CITY OF ALBUQUERQUE

**Re: Fountain Hills Plaza Assisted Living
4051 Vista Fuente Rd. NW
Request Permanent C.O. – Denied
Engineer's Stamp dated: 12/29/2017
Pad Certification dated: Not submitted
CO Certification Date: 9/6/2021**

FOUNTAIN HILLS PLAZA ASSISTED LIVING
GRADING PLAN

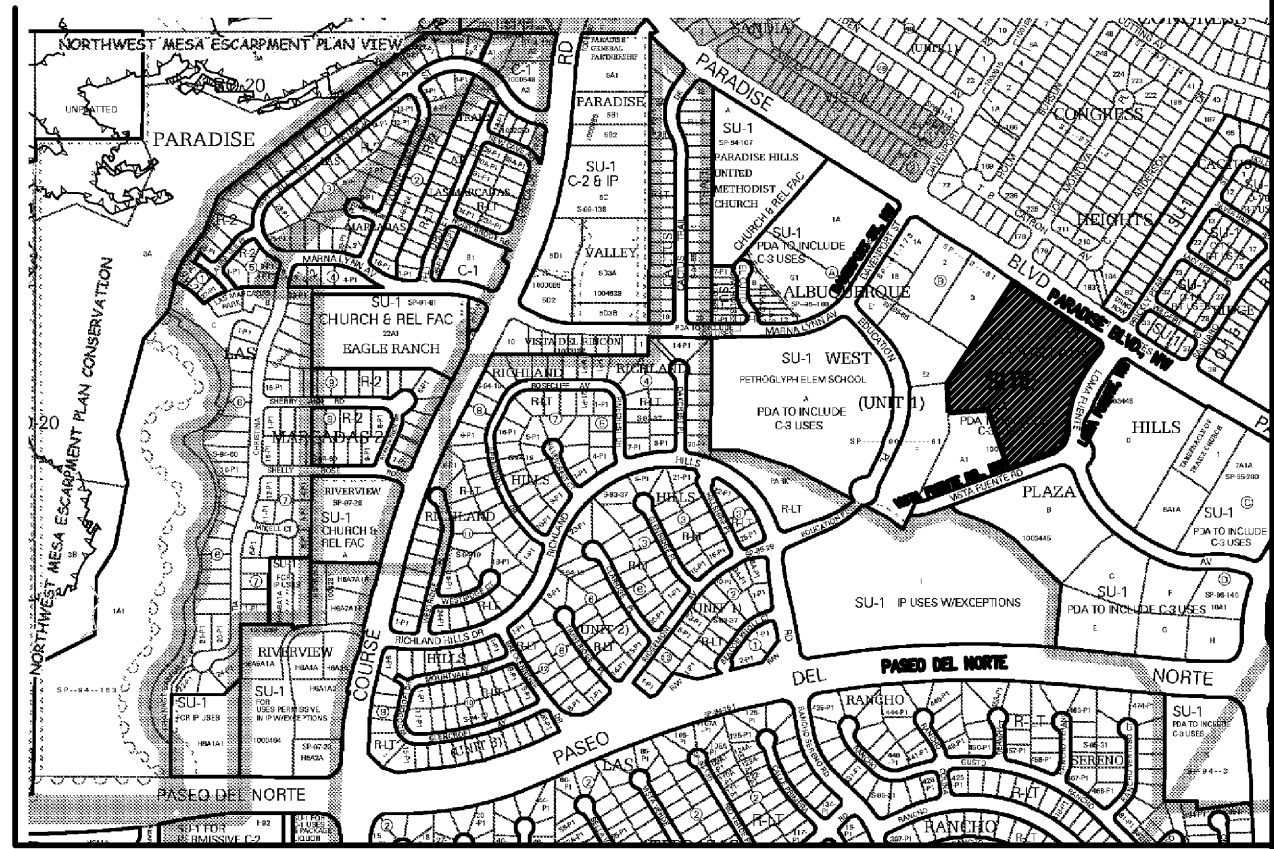
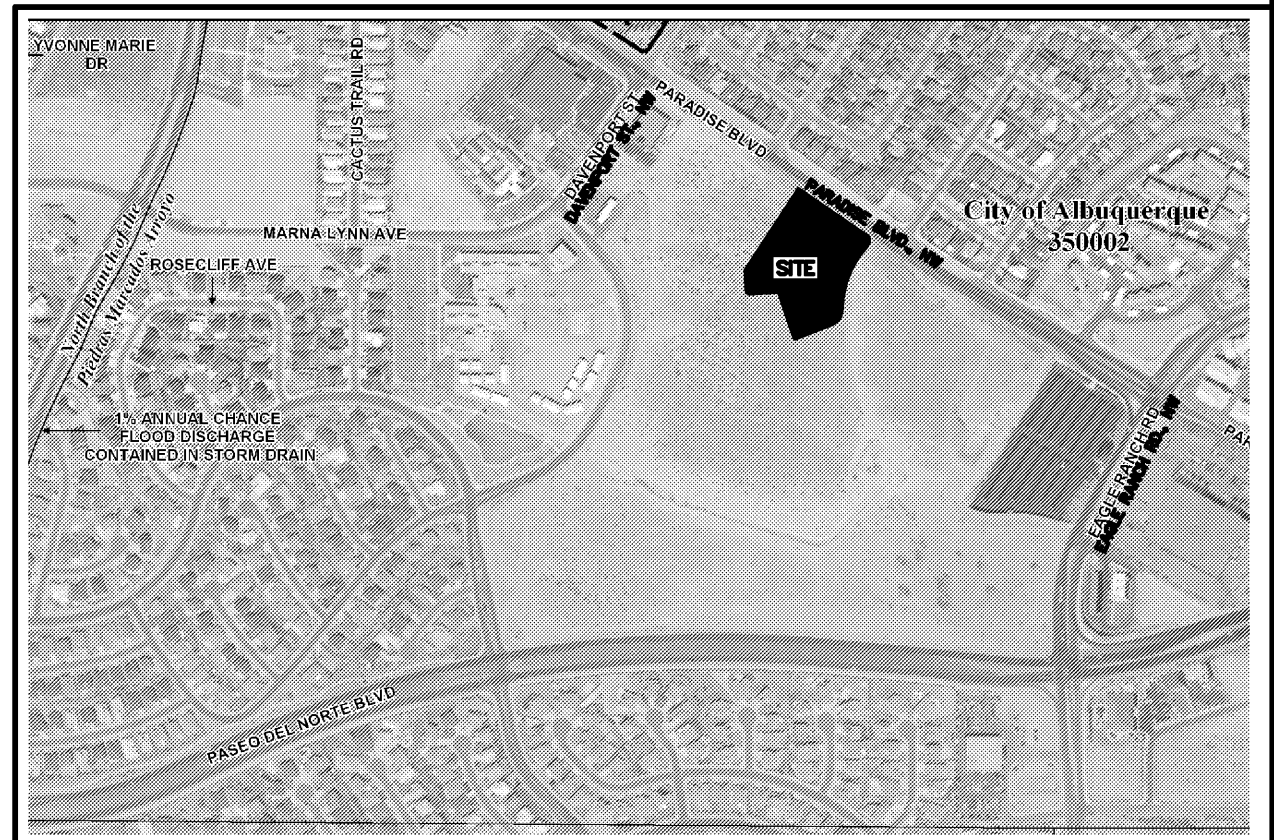
2. There are changes made to the plan which differ from the approved plan. Specifically the 8" storm drain from the court yard to the pond on the east follows a different path.

3. The plan needs to be an asbuilt plan highlighting the changes and calling them out.
 - (1) The sidewalk on the south side follows a zig-zag path where it is straight on the plan.

- (2) There is a sidewalk with stair on the east side which cuts through the pond.
 - (3) It is unclear if there are pipes under this sidewalk that connect the now split pond. It is also unclear how water is supposed to flow down from the upper portions of the site to the pond as there are no visible swales and water may just flow down the sidewalk bypassing the pond. (see picture below)

- (4) Rip rap rundowns are still shown on the plan where there are none with this new layout.
